MEMORANDUM

PROJECT: SCEGGS
JOB NO.: 160441

SUBJECT SCEGGS DARINGHURST SSD-8993 – REQUEST FOR ADDITIONAL INFORMATION

The NSW Department of Planning requested additional information in relation to SCEGGS Darlinghurst Concept and Stage 1 (SSD-8993) in letter dated 19/12/19.

Project
SCEGGS DARLINGHURST
MASTERPLAN
Drawing Title
PROPOSED MASTERPLAN
ENVELOPE ELEVATIONS
Drawing No.
AR.MP.3002
Revision
D

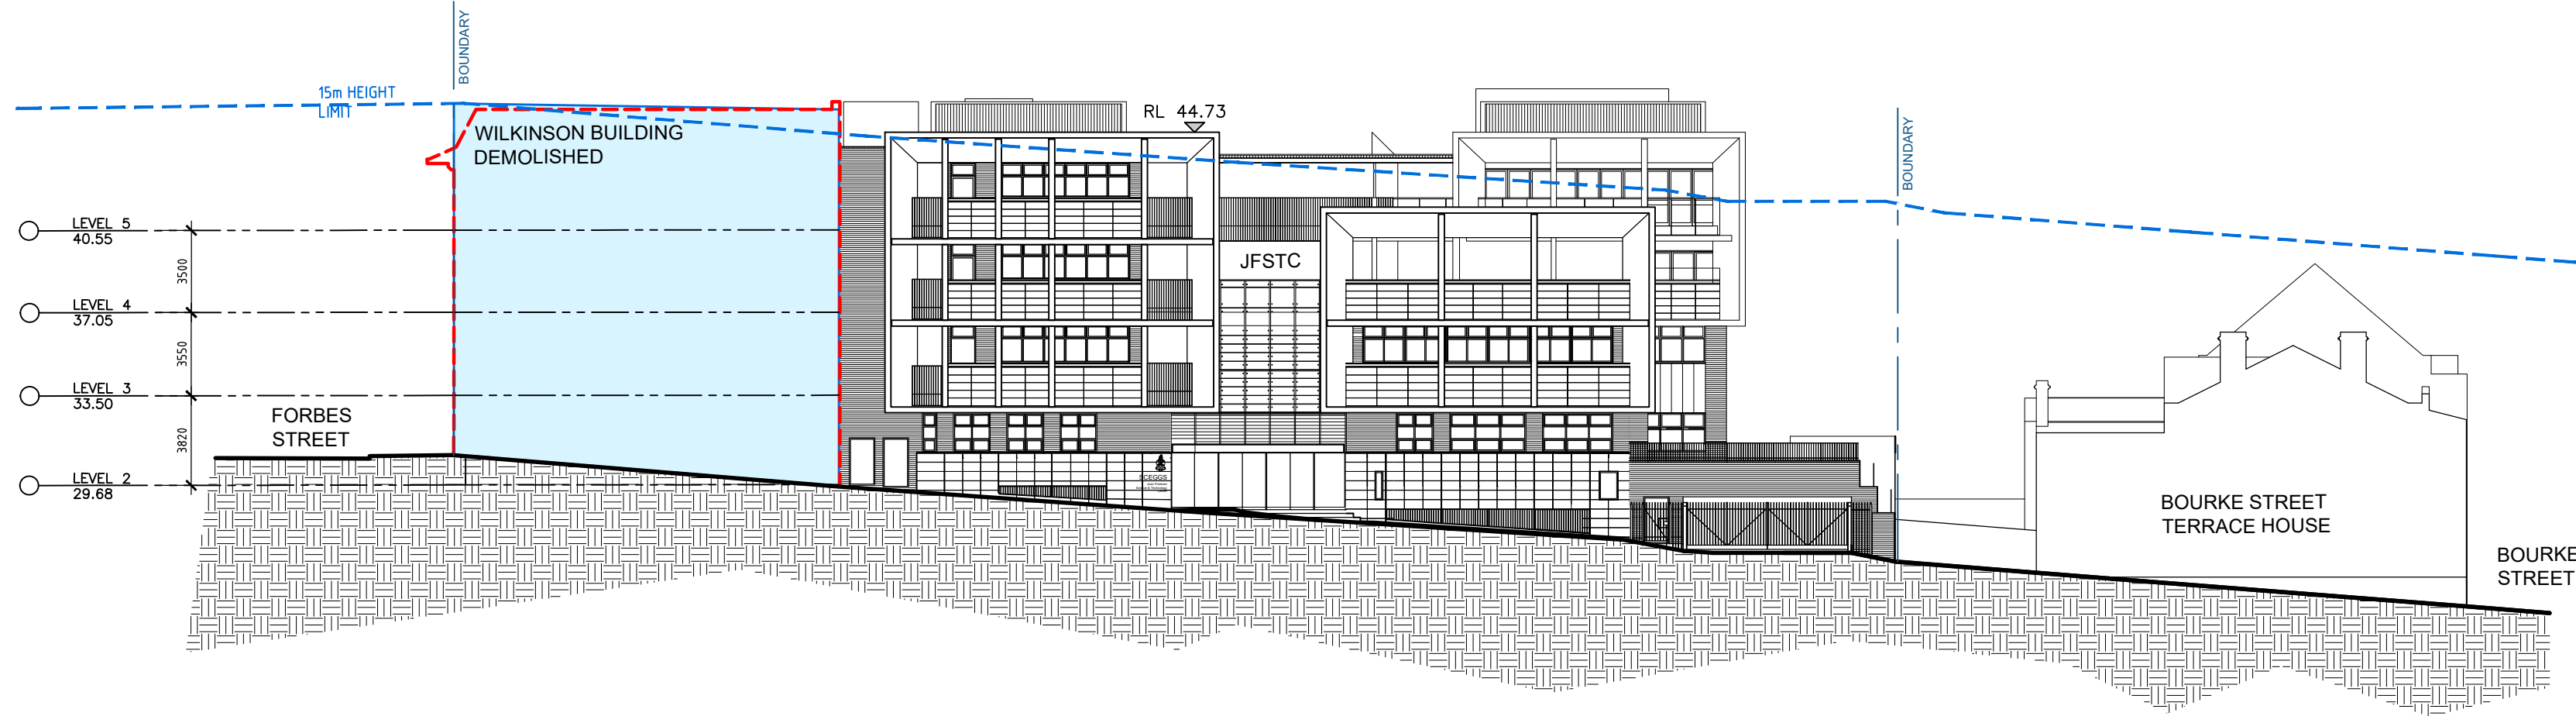
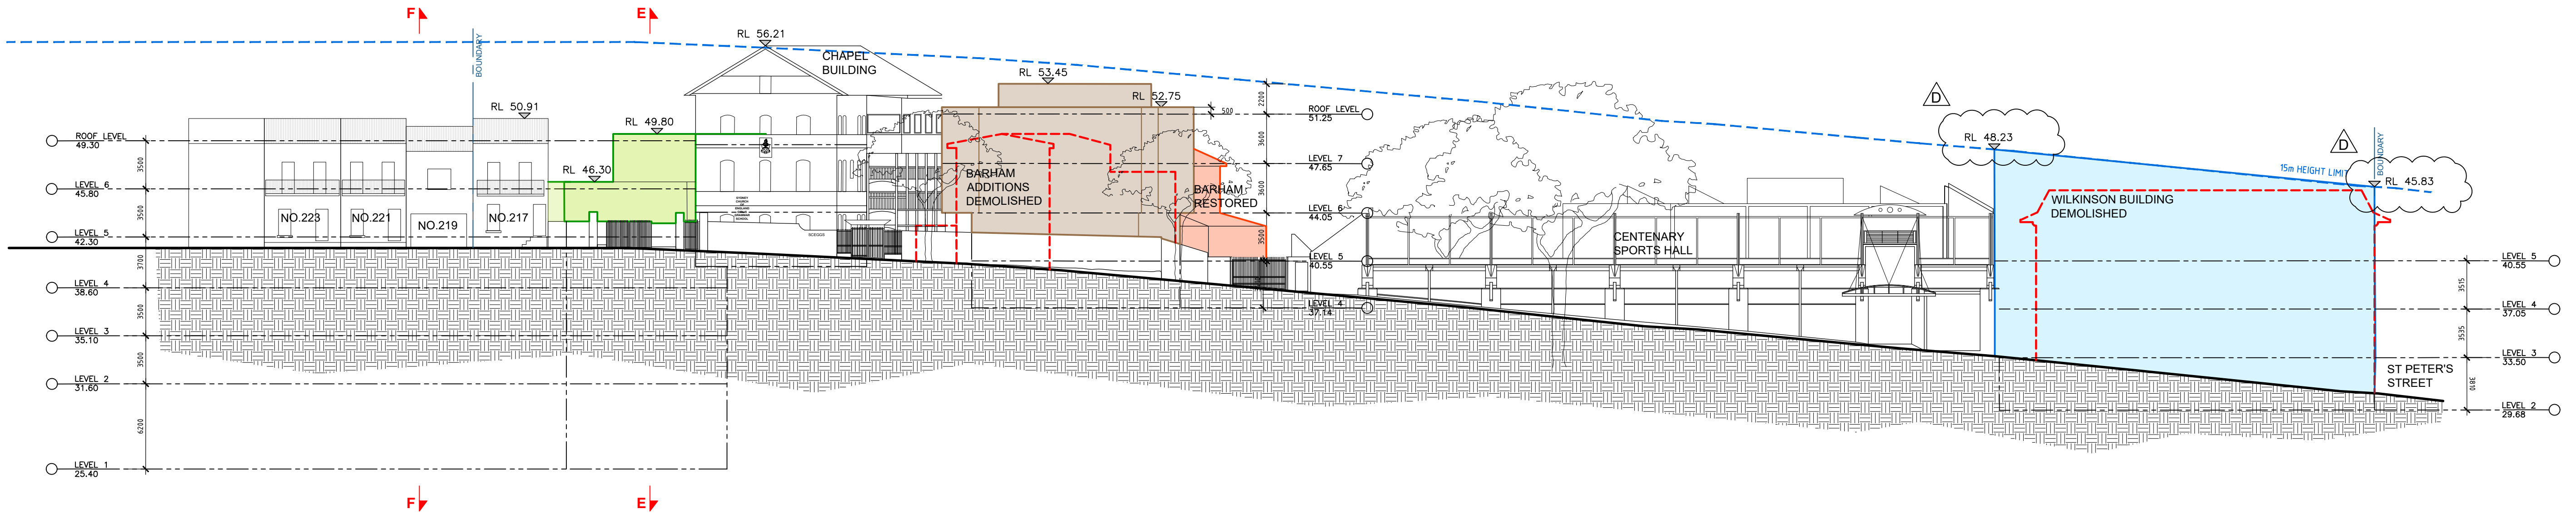
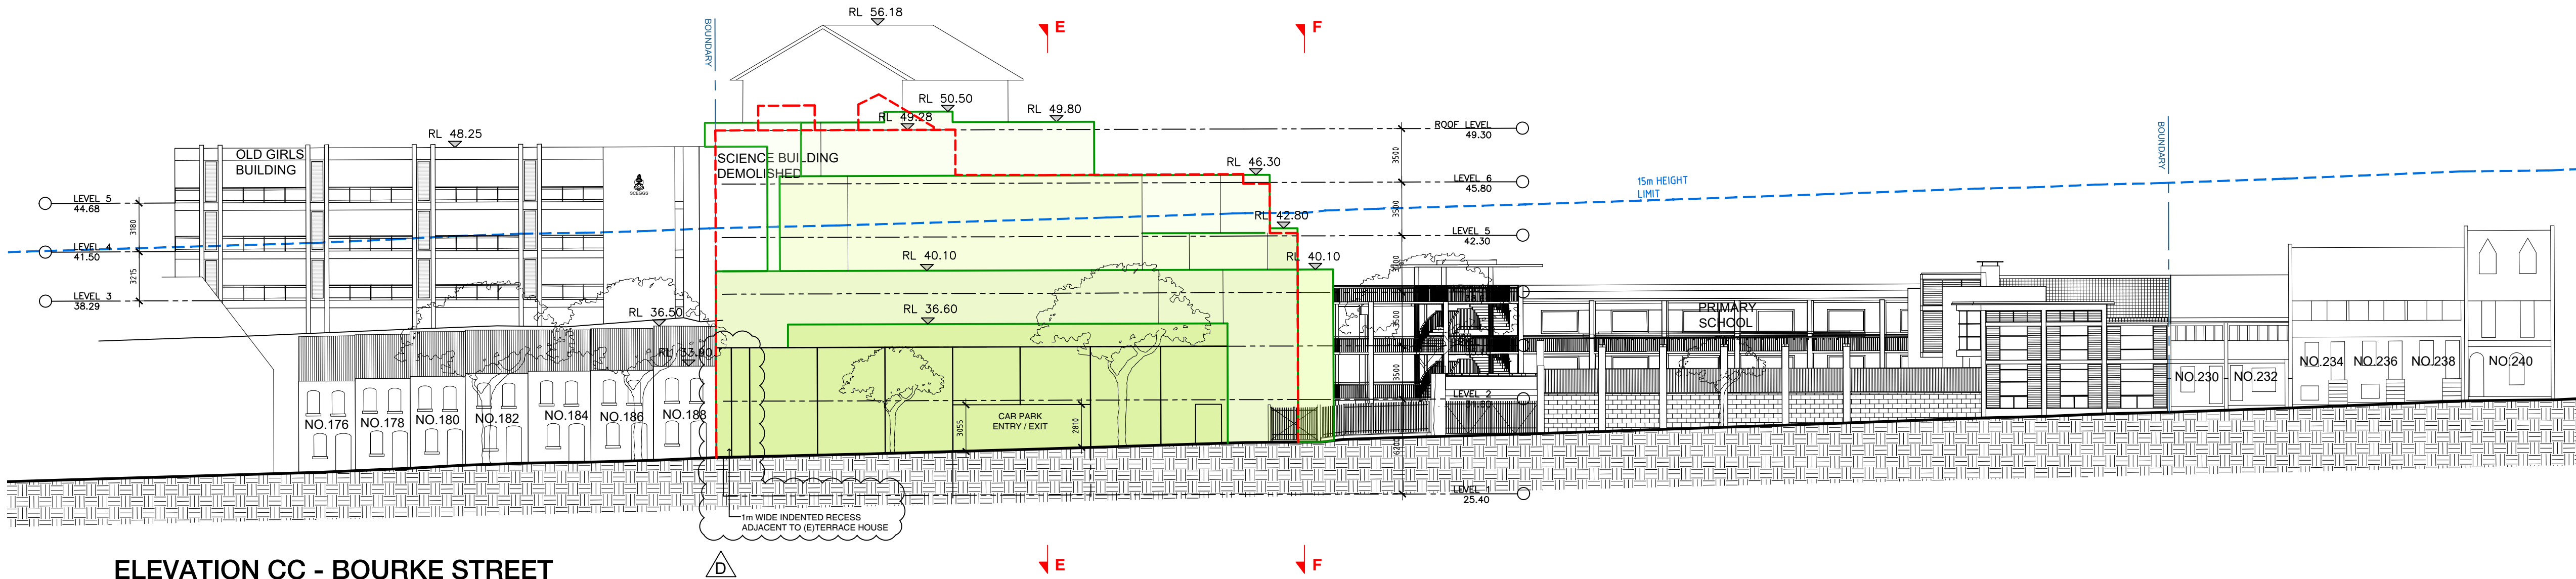
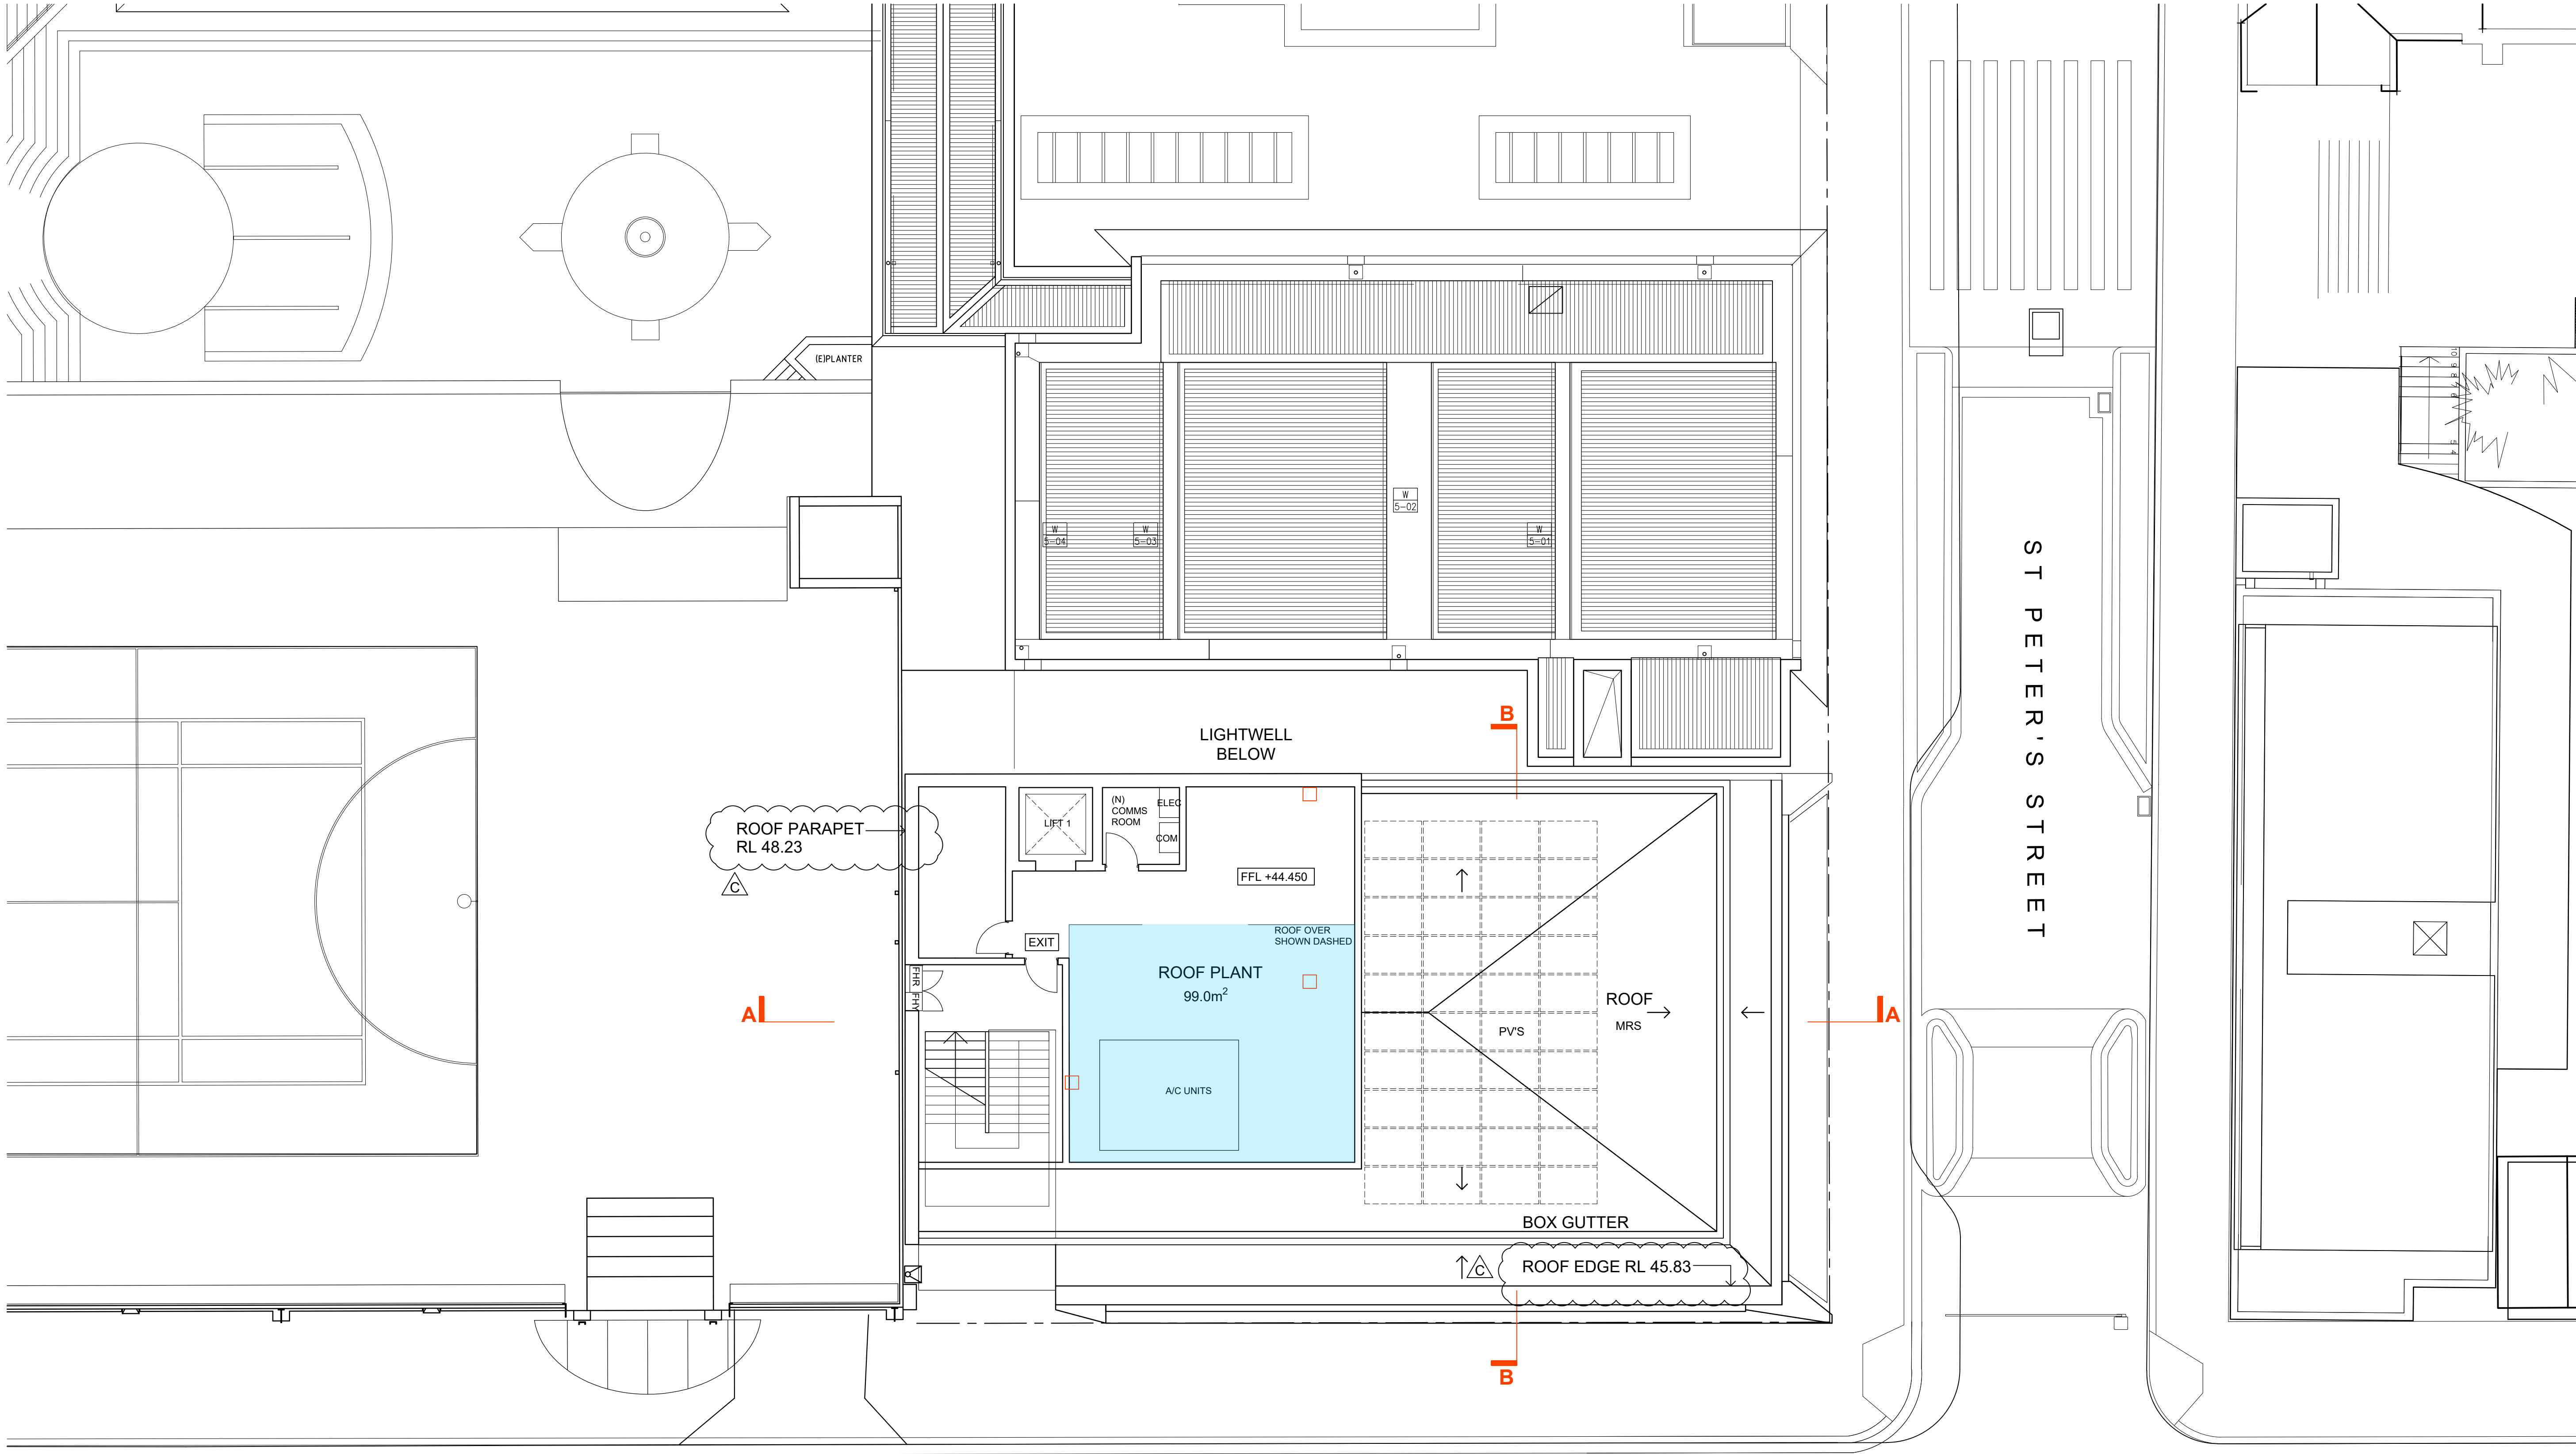
Request for Additional Information	Response
<p>Interface with Bourke Street terraces</p> <p>The recess shown in the detailed drawings (eg AR.MP.6003) between the heritage terraces and the proposed two storey street wall is not reflected in the proposed building envelope. The envelope should reflect the plans with the depth of the recess to be at least 1 metre from the face of the proposed new building to Bourke Street. The height of this indented recess is to also be amended in the envelope to reflect the detailed architectural drawings.</p>	<p>The envelope drawings have been amended to include a 1m wide indented recess adjacent to the existing terrace house on Bourke Street.</p> <p>The following drawings have been amended:</p> <ul style="list-style-type: none">- AR.MP.1102, Rev D- AR.MP.2101, Rev E- AR.MP.2102, Rev D- AR.MP.2108, Rev D- AR.MP.2109, Rev D- AR.MP.2110, Rev D- AR.MP.2111, Rev D- AR.MP.3002, Rev D

14. The Department notes that the architectural drawings (Concept and Stage 1) do not include the maximum RLs for Wilkinson House (drawings AR.MP.3002c, AR.DA.2105b, AR.DA.3002b). Provide updated architectural drawings annotated with the maximum RL heights (roof plan and elevation) for Wilkinson House, including highest point of plant enclosure(s).	<p>The Architectural Drawings have been annotated with the maximum RL heights.</p> <p>The following Architectural Drawings have been updated:</p> <ul style="list-style-type: none"> - AR.MP.3002, Rev D - AR.DA.2105, Rev C - AR.DA.3002, Rev C
<p>16. For reference:</p> <p>a) update (to include RtS changes) and provide a copy of the 'landscaping/tree' image that was located at page 13 of the EIS Architectural Design Report.</p> <p>b) provide an 'as proposed' car parking/access image, based on the image that was located at page 15 of the EIS Architectural Design Report.</p> <p>c) provide a photograph of the Old Gym Building.</p>	<p>Architectural plan diagrams from page 13 and 15 of the EIS Architectural Design Report have been updated as requested to show the RtS proposal.</p> <p>Updated diagrams are attached.</p> <p>A photograph of the existing Old Gym Building is provided below.</p>
